Lot 37
 Plan 2
 Parcel: 3414203003
 Elevation: Craftsman
 Crawl-Space
 Master Plan#: M153729
 Model: M1002

PLOT PLAN

444 GARDEN PARK AVE. CALHAN, CO 80808
 MAYBERRY, COLORADO SPRINGS FILING NO. 1
 A PORTION OF SECTION 14 & 15, T 14S, R 63 W, 6TH PM
 COLORADO SPRINGS, EL PASO COUNTY, COLORADO

DISAPPROVED
 Plan Review

PLOT PLAN

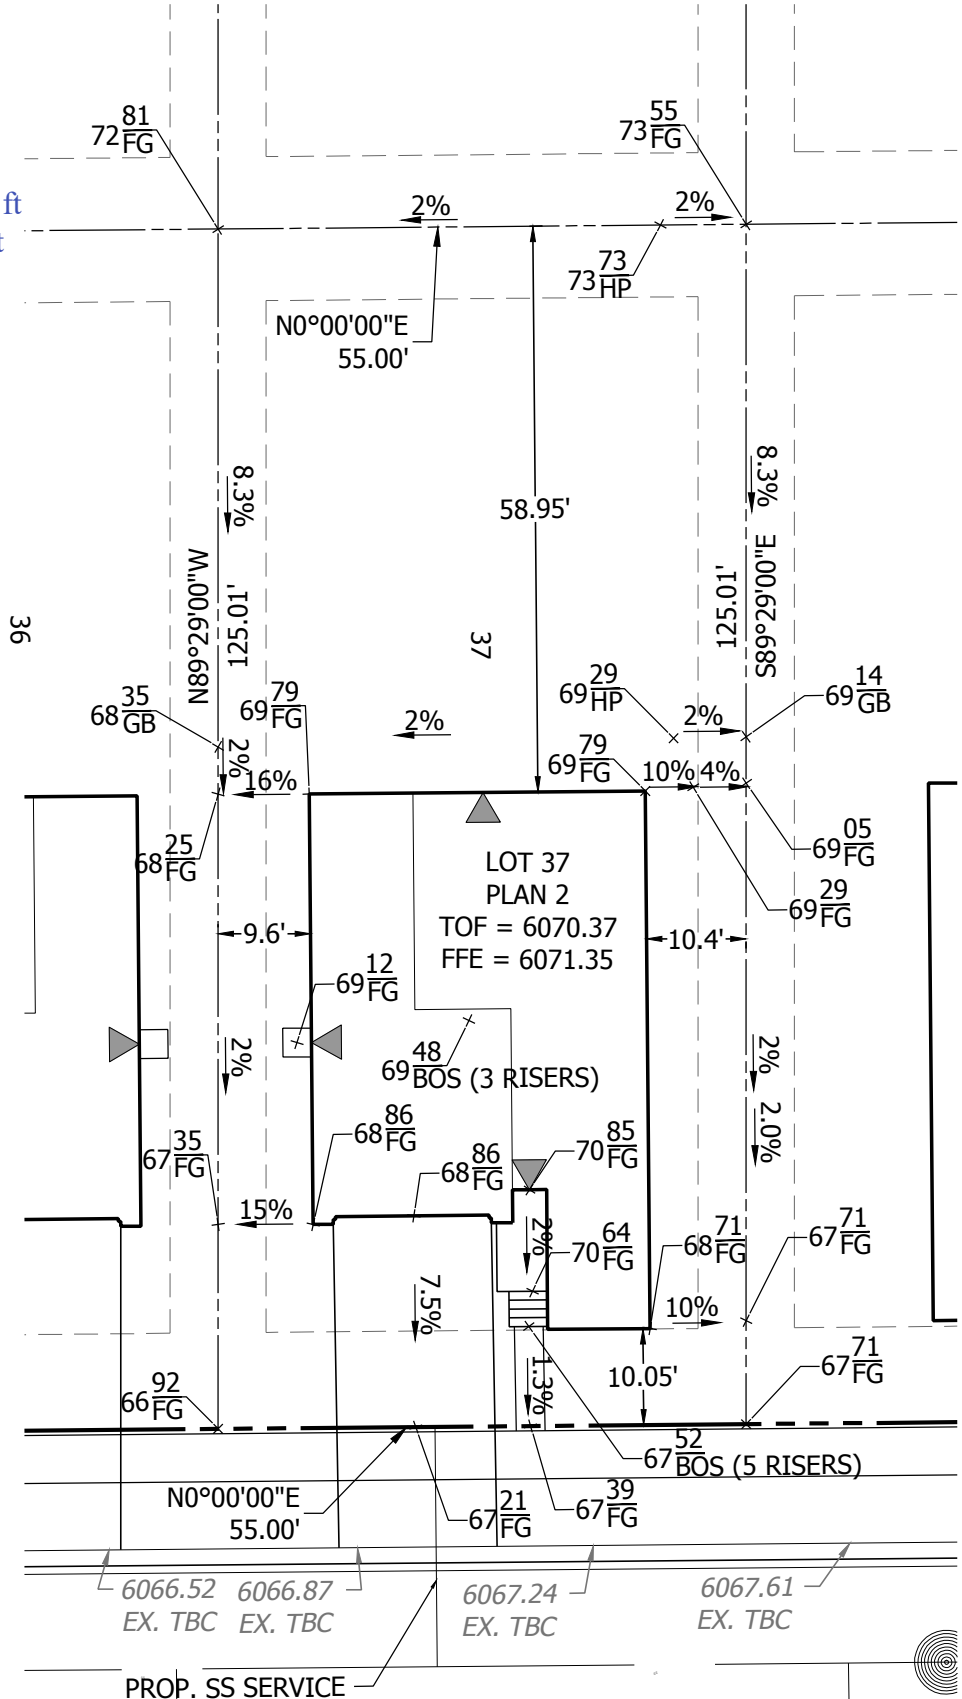
Provide site data (lot size,
 residence size, % lot
 coverage and average
 building height) on all site
 plans.
